Response to Planning Application

Application ref: BE/95/21/DOC

Description:. Approval of details reserved by condition following BE/133/16/PL relating to conditions 9-landscape scheme, 10-dust bin enclosure, 11-placement of 4 nesting opportunities & roosting structure, 12-cycle parking, & 16-lighting details

Location: Beech Cottage 99A North Bersted Street Bersted PO22 9AF

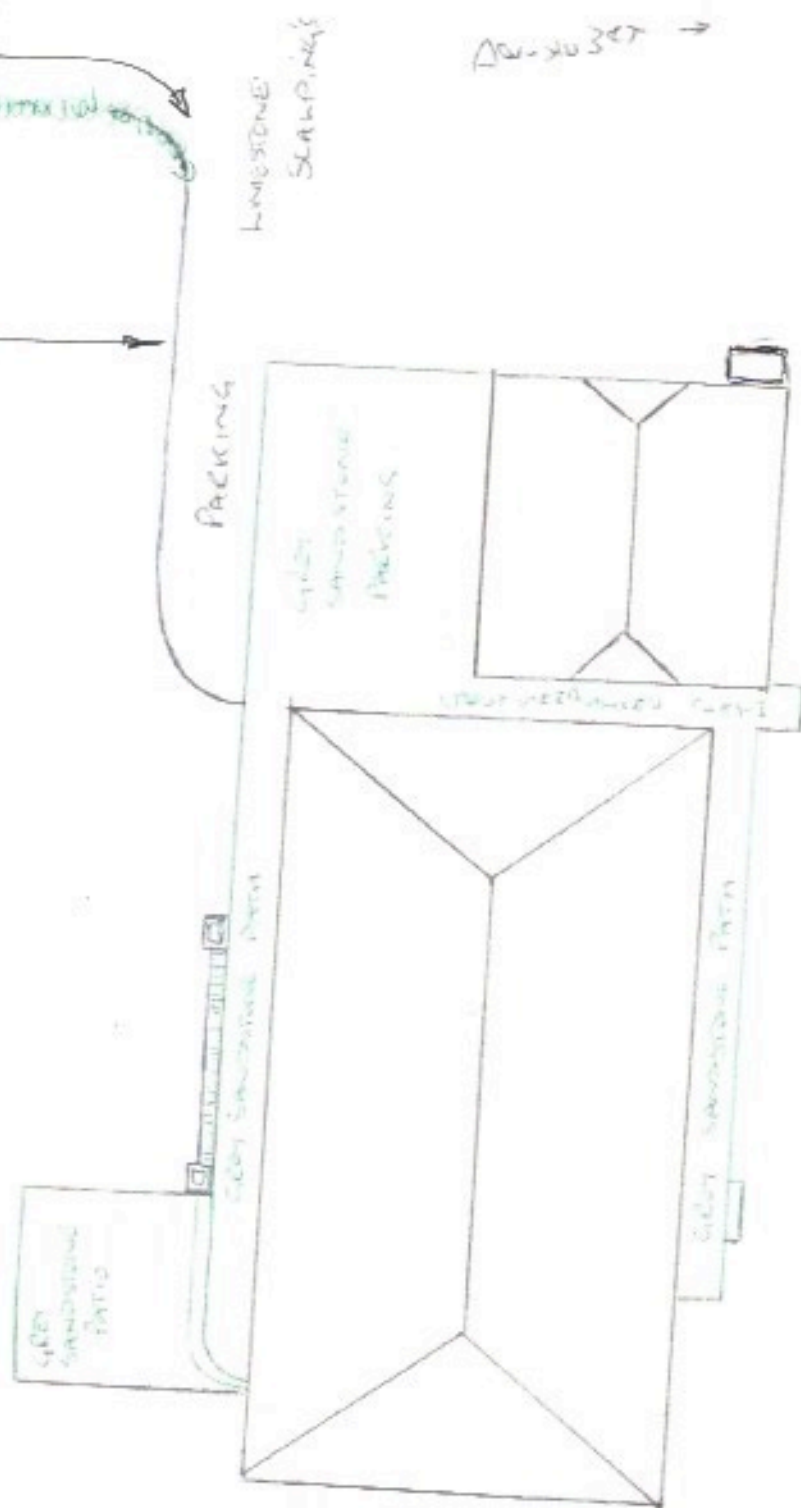
Whilst the proposal does not have any impact on street scene, the detail submitted in the Landscaping Scheme dwg is limited in detail and requires detail of actual plant quantities, planting density, species and size at time of planting for the New planted hedge area. This information can be added to the submitted drawing but should be included to qualify for the discharge of landscape condition 9 under this application BE/95/21/DOC
